To : Planning Inspectorate Team. Mr James Bunten
From : Mr R G Fox Registration Number PORT003.

Subject : Bristol to Portishead Railway Branch Line.
Planning Application TR040011.

Metrowest Ph1 Representation Form.

Drawing No.	Revision
467470.BQ.04.20-400	N

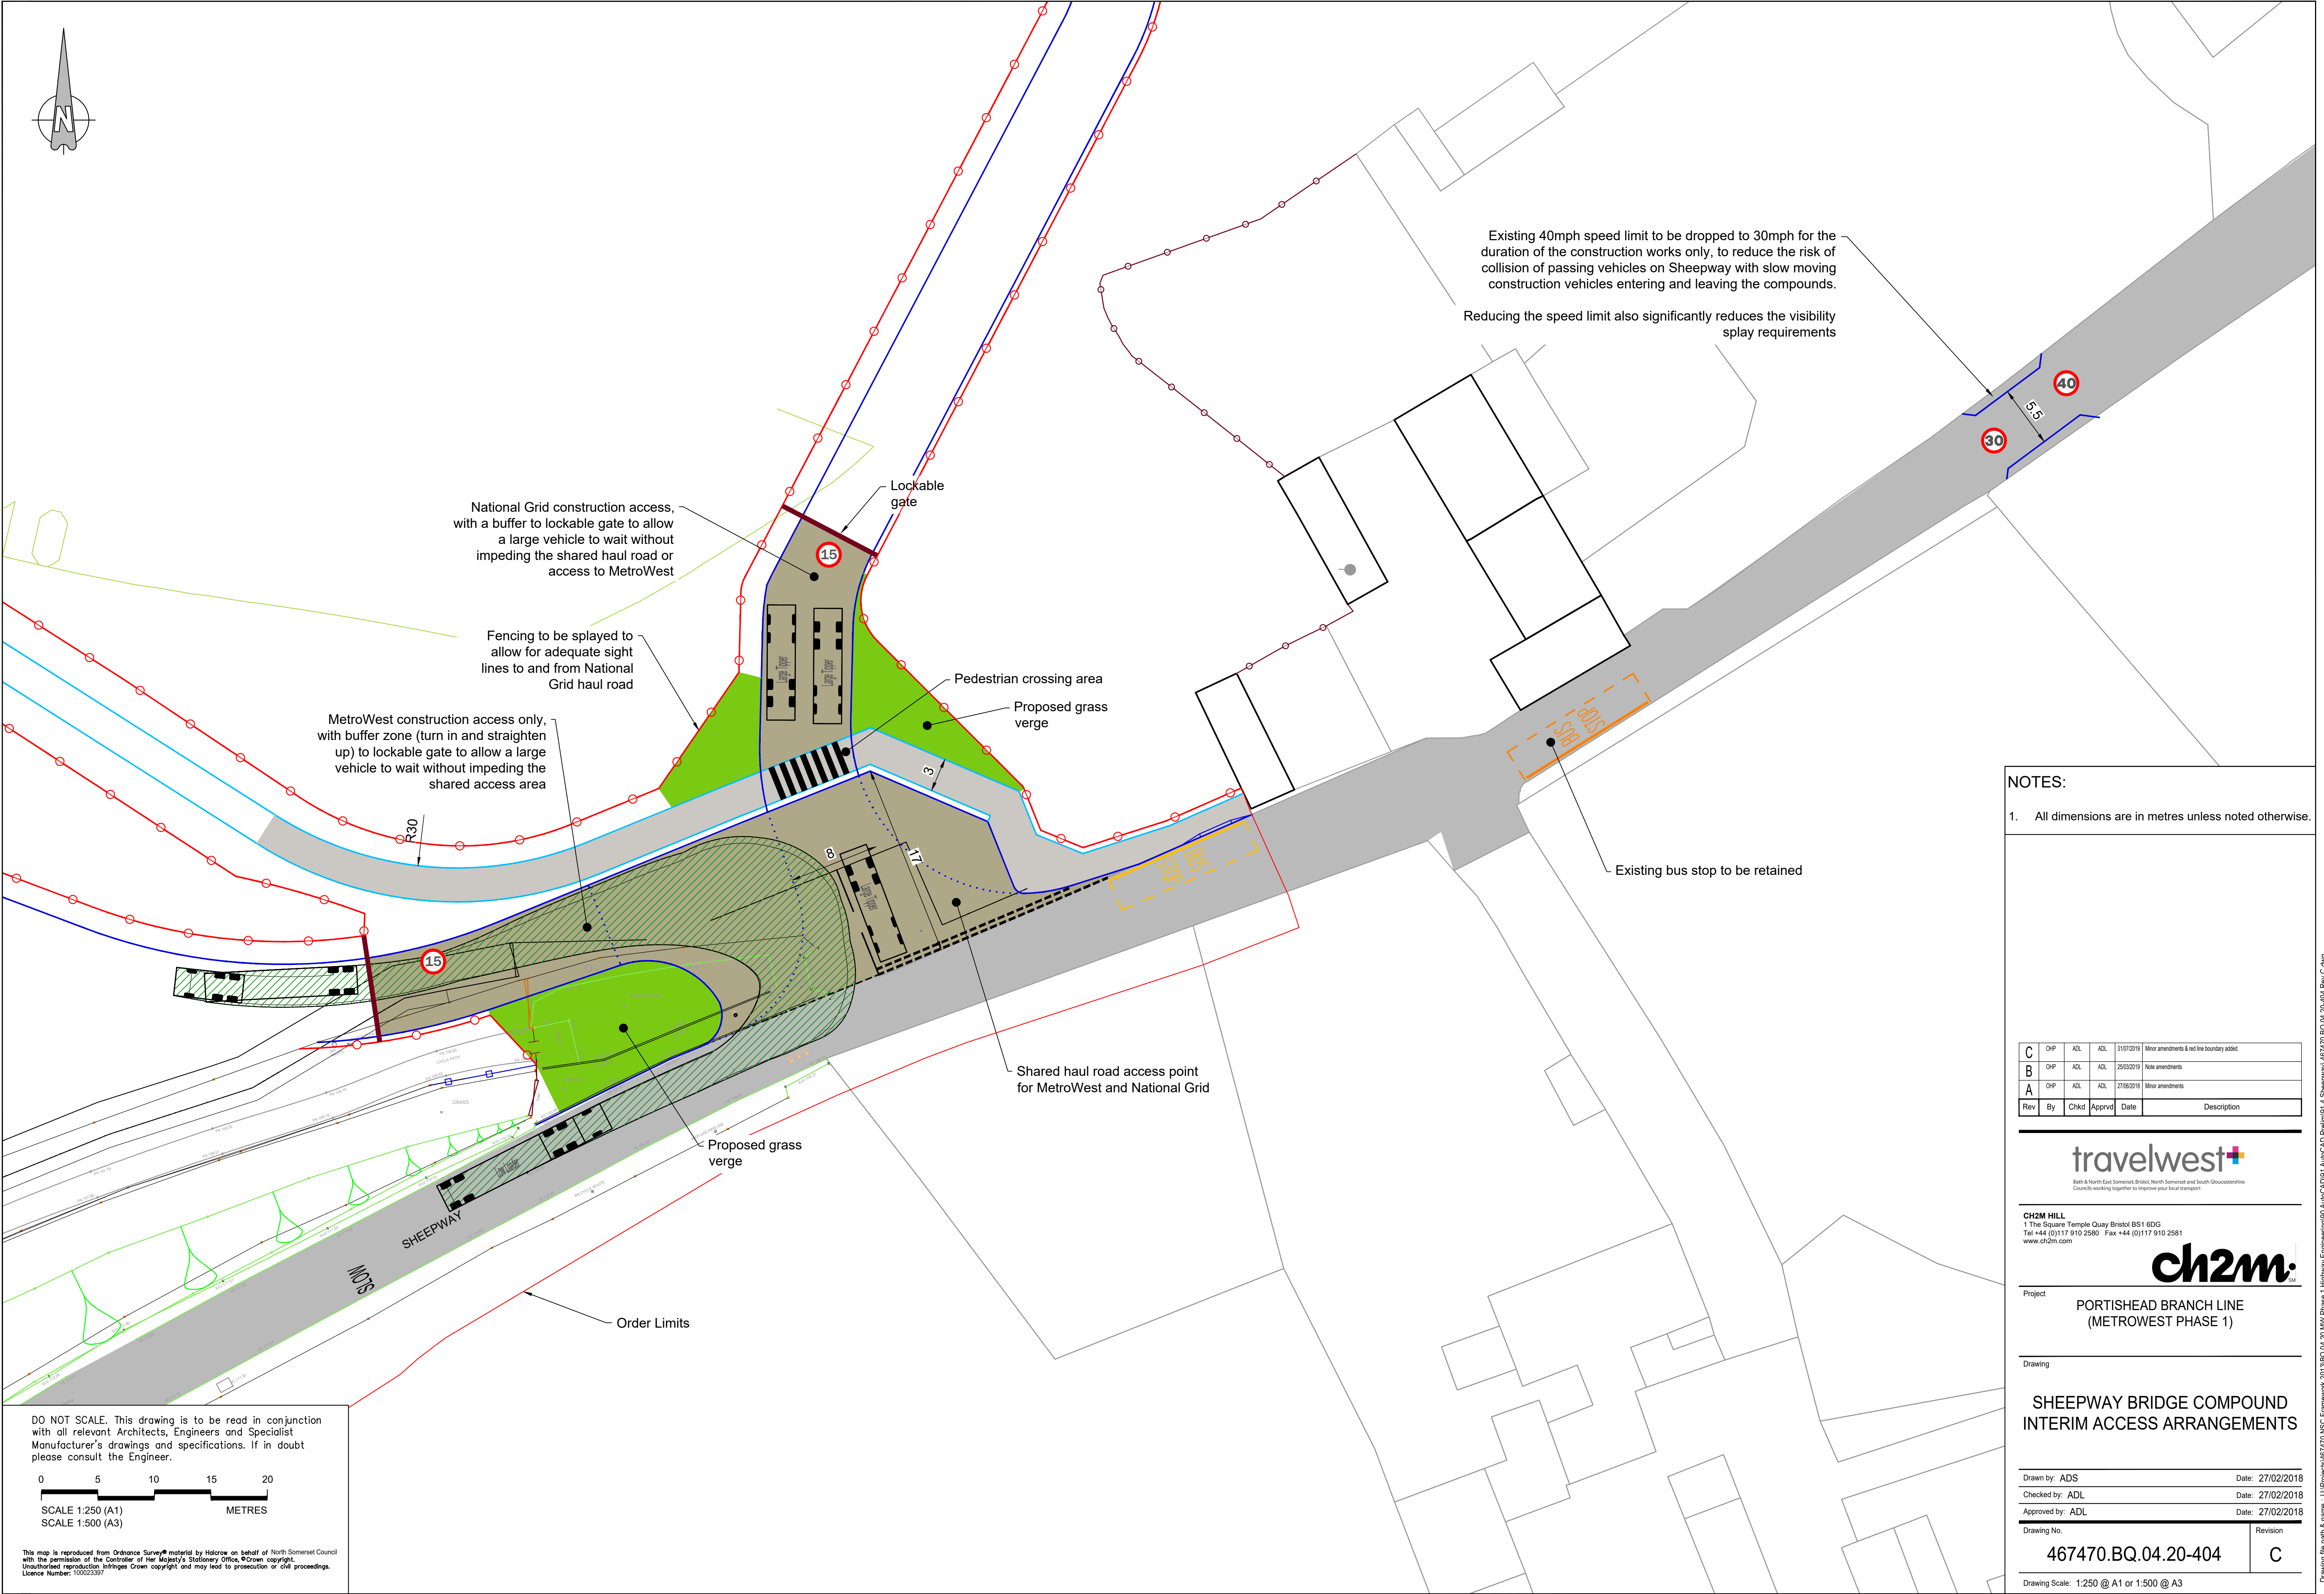
1. Ref drg. 467470BQ04-20-600. The new access on the north verge of the A369, due west of the Portbury Hundred footbridge, is opposite a level crossing in the disused railway line. These should be used during construction to access the fields required both south and north of the railway line to minimise or eliminate use of the access AW3.2 in Sheepway.

This would be appreciated greatly by the residents of the Hamlet, and the occupants of the mobile home site, that use Sheepway road every day. Access AW3.2 is directly opposite the access to the mobile home site, also access to the business park, and access to the allotment gardens, not a good design from Metrowest.

Beneath the existing private access from Sheepway, contiguous to Priory Croft, now used for horse riding and farm tractor purposes only, are very high pressure kerosene fuel lines (720psi). Will these lines remain safe when access AW3.2 is in use by Metrowest ?

A proposal is that it would be much safer to separate the envisaged access traffic whereby the existing traffic remain using the existing access unchanged, and the Metrowest traffic use a relocated AW3.2 to be alongside AW3.3 since there are splayed twin accesses there already. This revised position for AW3.2 could then follow the original track diagonally across the field, as before, to the existing ditch underpass.
